Subject: **Request for Modification to Individual Section 404 and Section 401 Water Quality Certification** for the Winston-Salem Northern Beltway from US 52 to US 311 (New Walkertown Road), Forsyth County. Federal Aid Project No. NHP-0074(213), TIP Nos. U-2579D, E& F. Division 9.

The North Carolina Department of Transportation (NCDOT) requests modification to the existing Section 404 Individual Permit and Section 401 Water Quality Certification for the proposed Winston Salem Northern Beltway from US 52 to US 311 (TIP U-2759 D, E, and F) in Forsyth County. This project is currently under construction.

Permit Impact Site Modifications

PROJECT REFERENCE NO. <b>U-2579D, E &amp; F</b>	SHEET NO. <b>25</b>
ROADWAY DESIGN ENGINEER	HYDRAULICS ENGINEER
<b>DOCUMENT NOT CONSIDERED FINAL UNLESS ALL SIGNATURES COMPLETED</b>

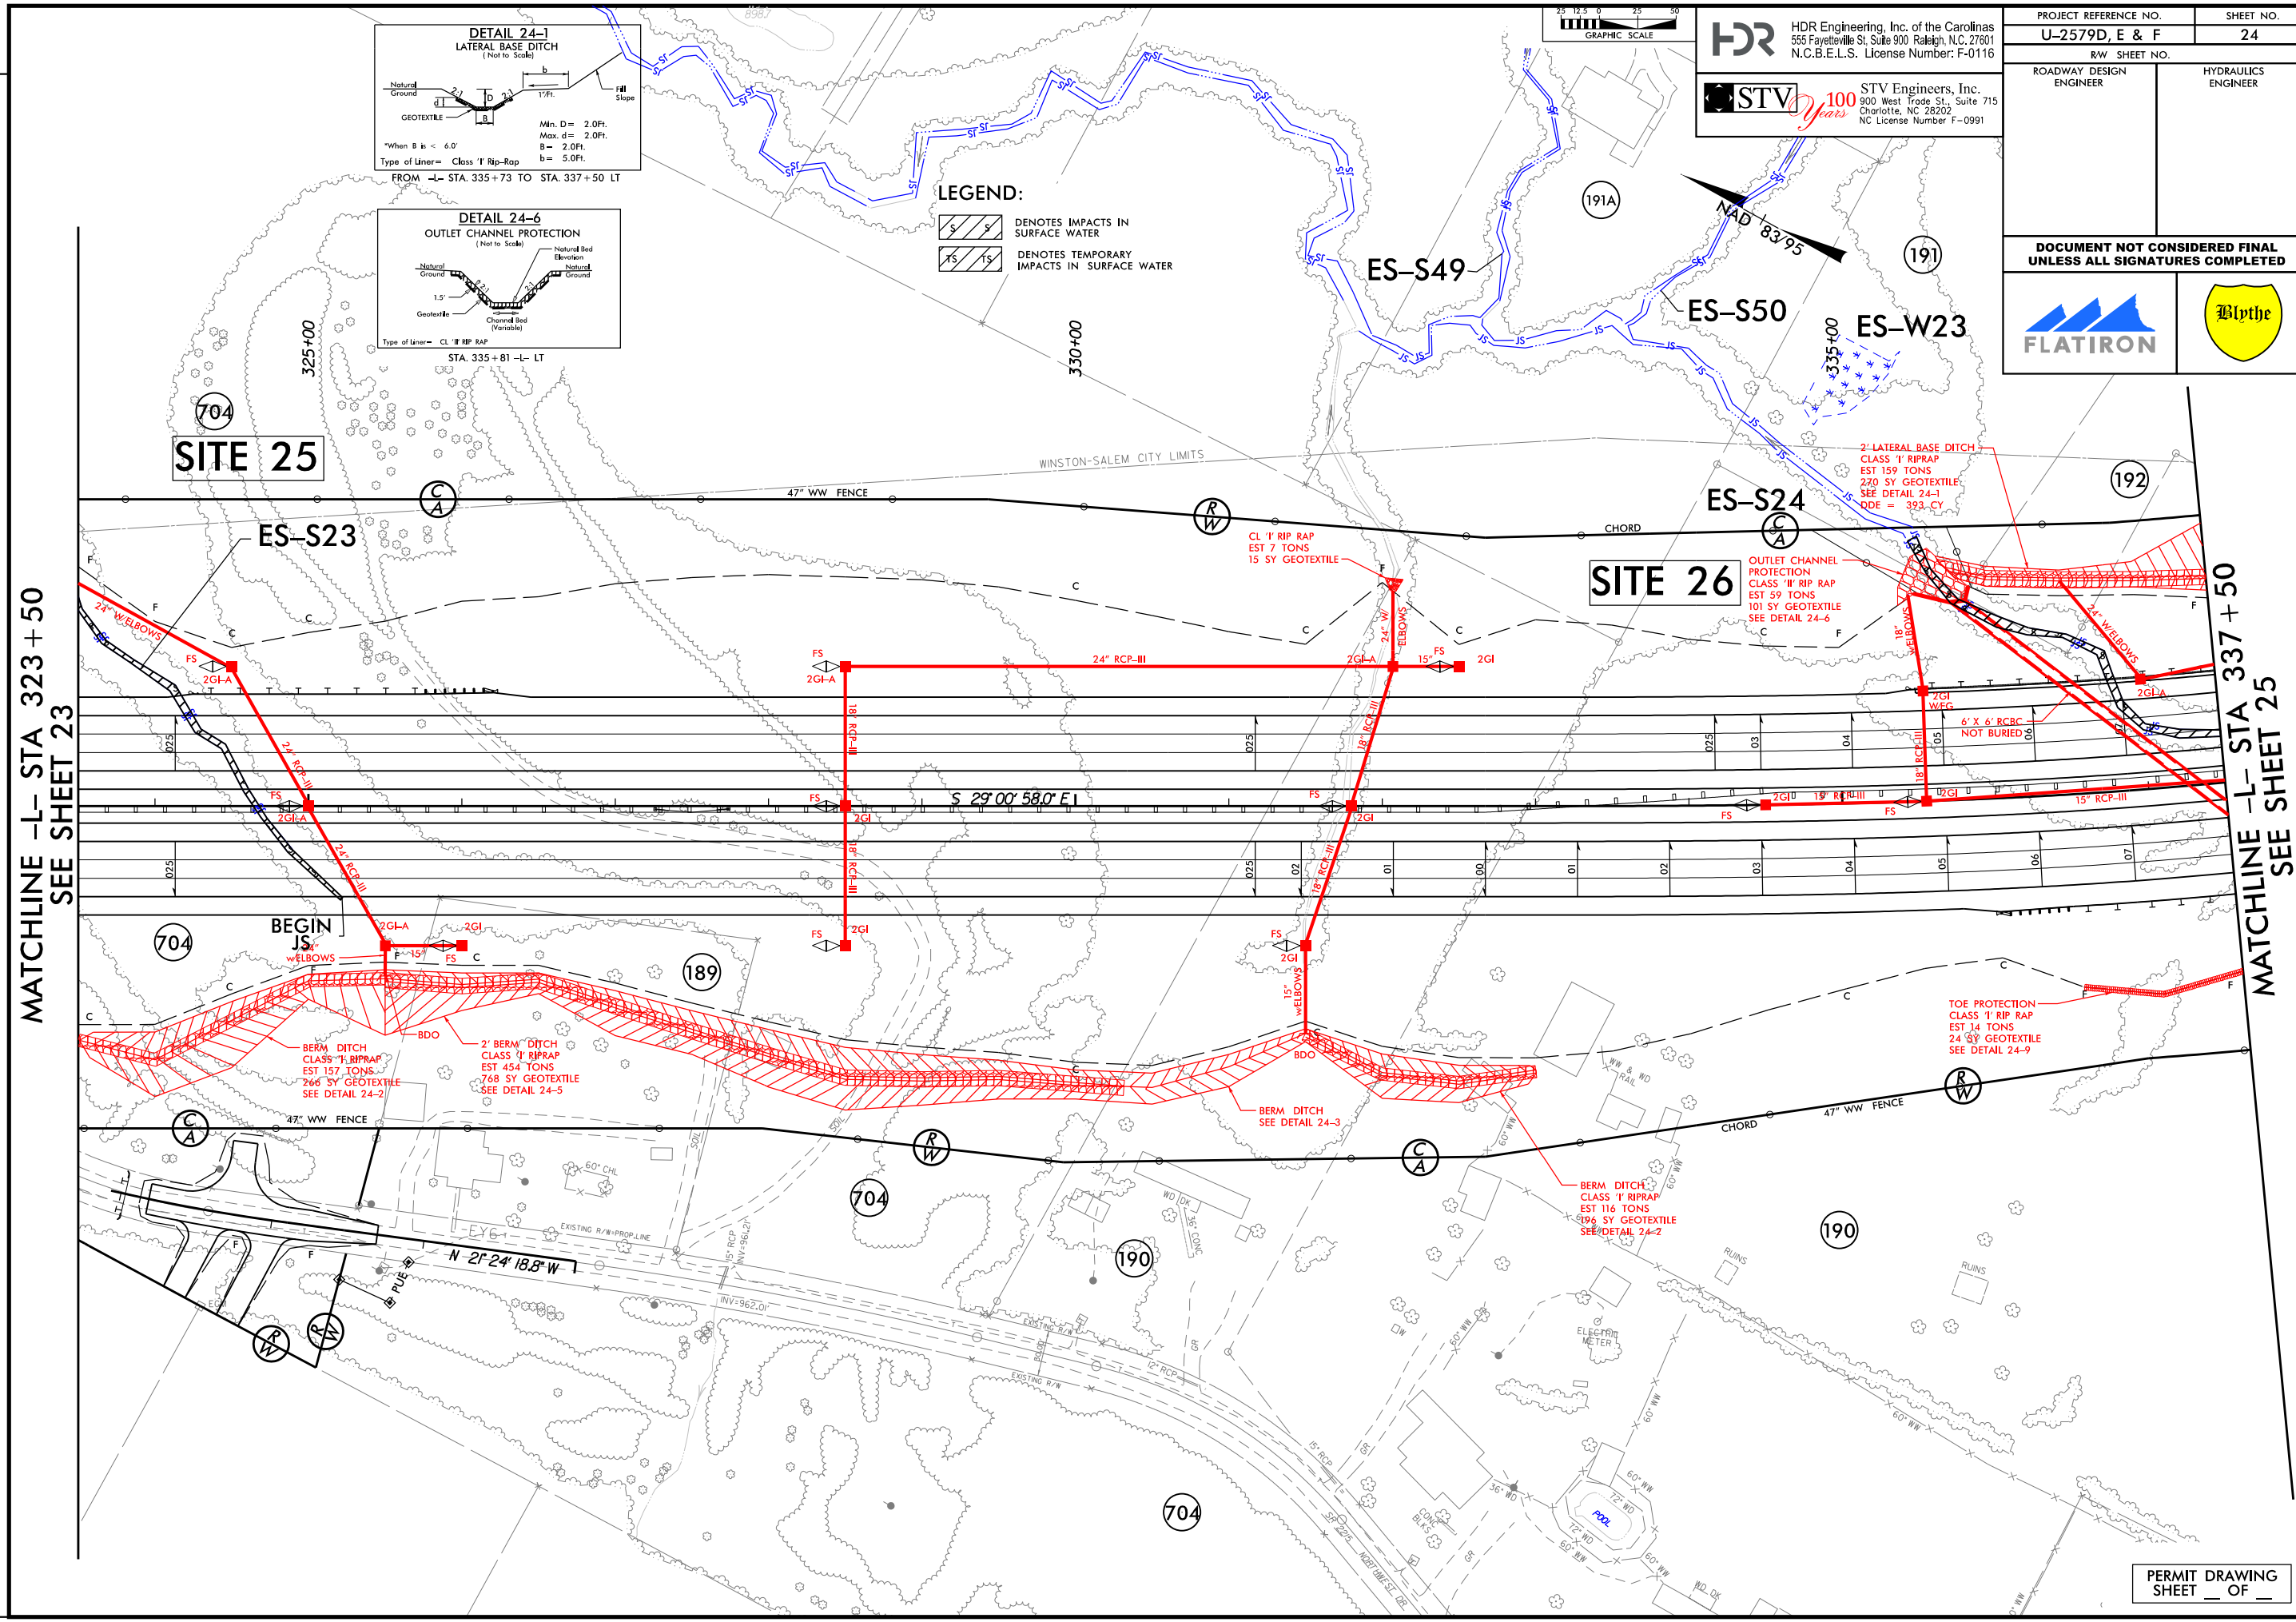
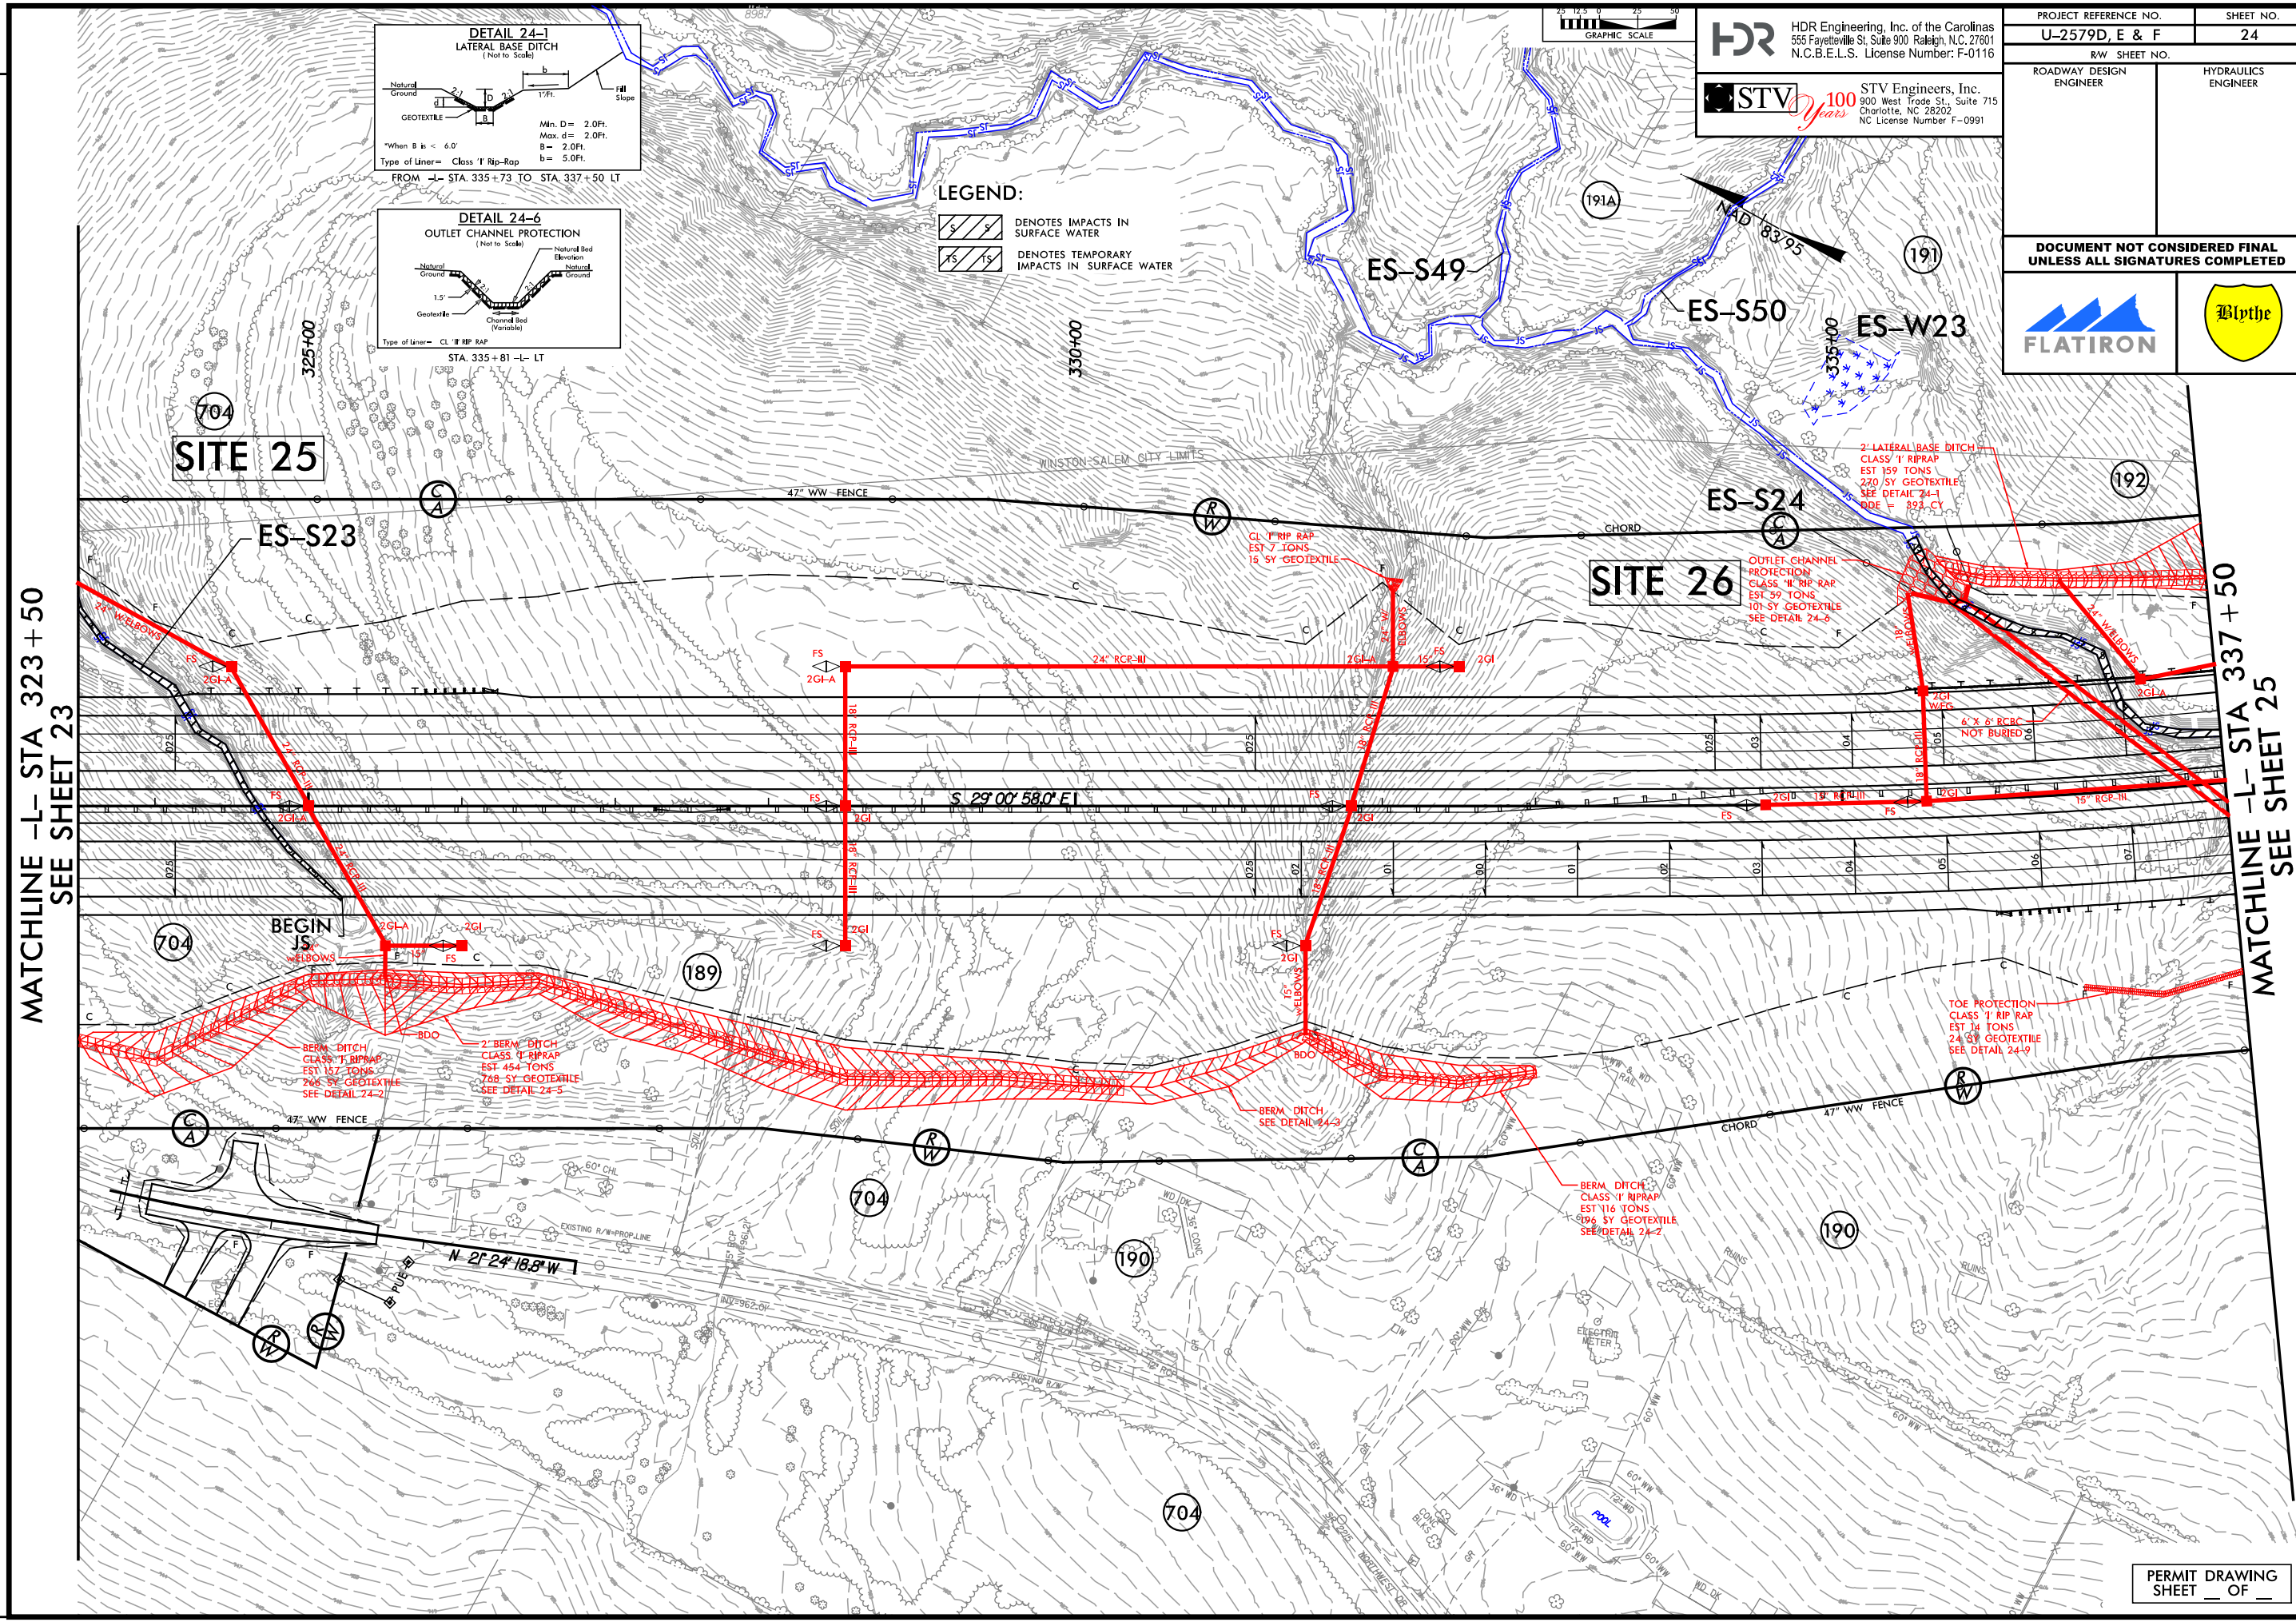
Site 26 (Sheets 24 and 25): Site 26 impacts changed as a result of the final design of the 6x6 RCBC in which the culvert length was increased from preliminary plans. When reviewed with the previous modification the new culvert length resulted an increase in permanent impacts by 4 linear feet for the RCBC and by 5 linear feet for bank stabilization. The temporary impact at this site was reduced by 2 linear feet. There will be a total of 523 linear feet of impact due to the RCBC, 29 linear feet of bank stabilization, and 18 linear feet of temporary stream impact at Site 26.
